Subject: VA-23-00003/SE-23-00010 - Sparks Park
I-90 Exit 70 Lt., Easton State Airport vicinity

We have reviewed the proposed project and have the following comments.

PRELIMINARY SITE PLAN
 MOUNTVIEW GROUP LLC TRAVEL CENTER
 WEST SPARKS ROAD
 EASTON, WASHINGTON

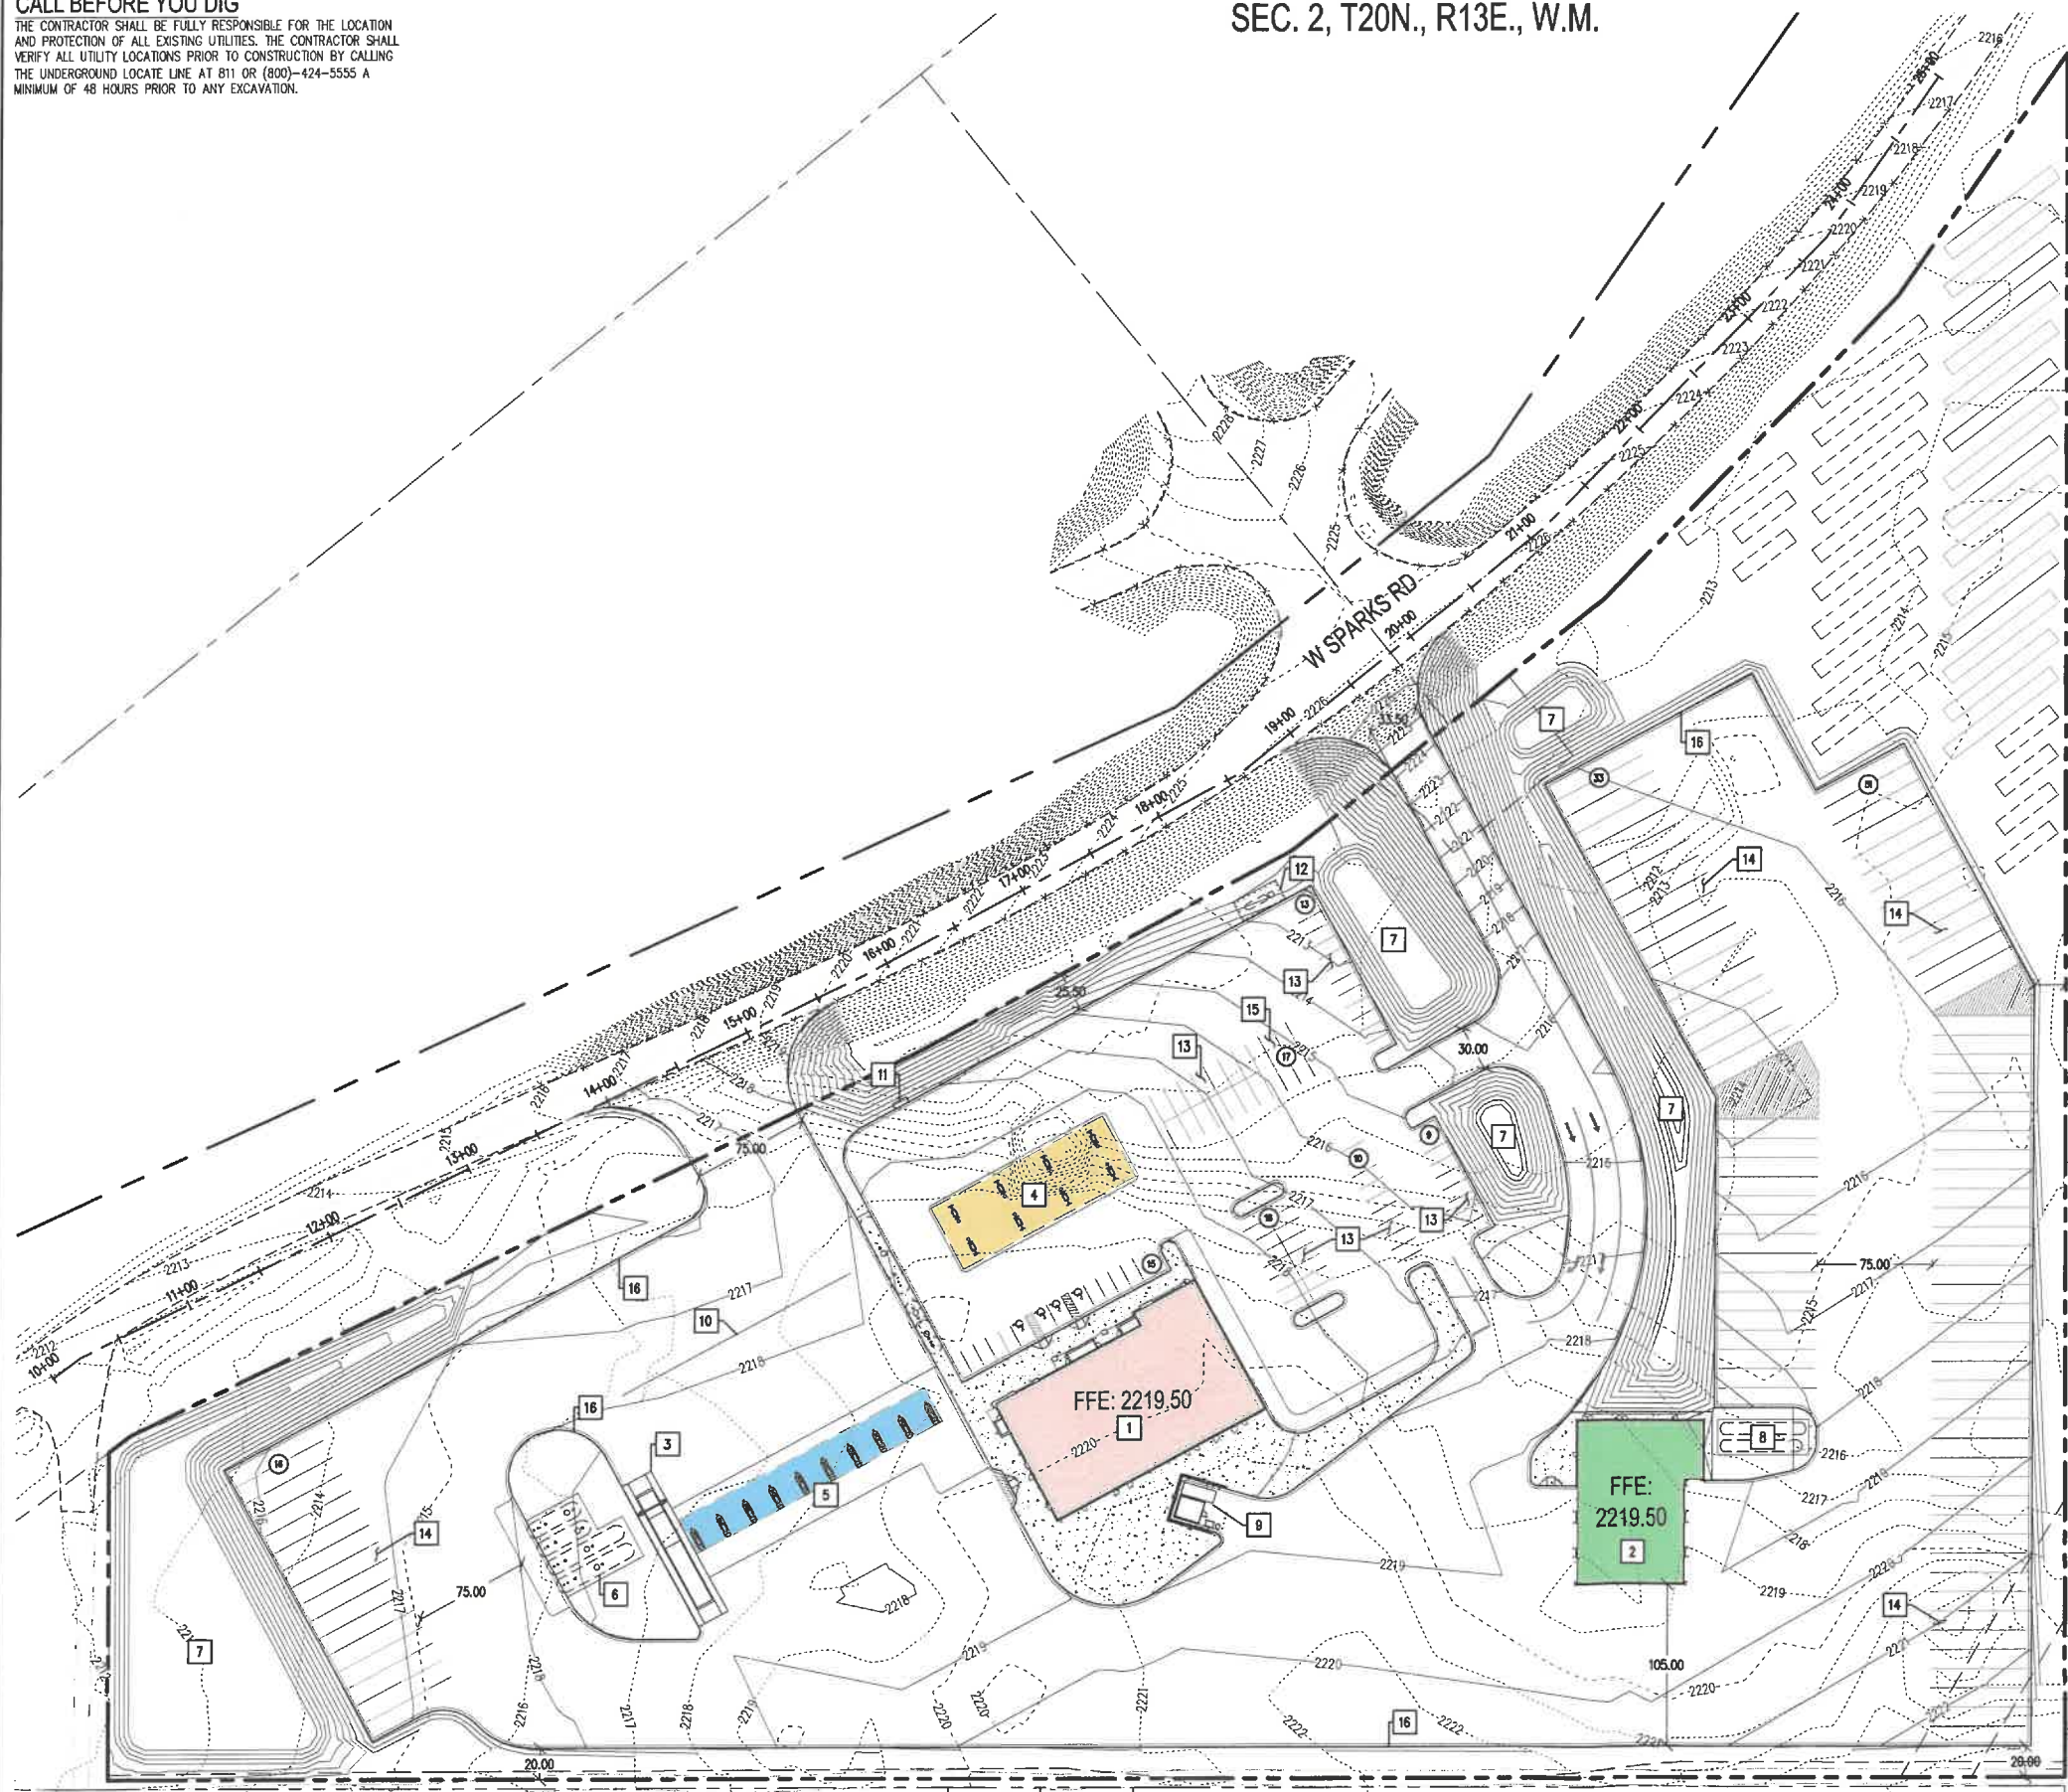
- The subject property is adjacent to two WSDOT owned and operated facilities, the Interstate 90 (I-90) West Easton interchange (Exit 70) and the Easton State Airport. WSDOT has acquired all access rights to I-90, including the on- and off-ramps, and along 130' of W Sparks Rd. and 130' of Sparks Rd. Our right-of-way records indicate there is an approximately 110' wide break in our limited access control along Sparks Road at the easterly terminus of the Exit 70 crossroad. The proposed driveway can be allowed; however, the driveway must be located entirely within this break and the connection shall not cross the existing limited access boundary.

Further, the proponent is required to dedicate additional access rights to the department along the proposed driveway a distance of 130' beginning at the centerline intersection of the Sparks Road/Exit 70 crossroad intersection. The proponent should contact Mark Kaiser of the WSDOT South Central Region office at (509) 577-1668, for specifics.

- Any proposed lighting must be directed down towards the site and away from I-90 and the airport.
- Finally, any outdoor advertising or motorist signing considered for this project will need to comply with state criteria. Please contact Trevor McCain of the WSDOT Headquarters Traffic Office for specifics. He can be reached at (360) 705-7282.
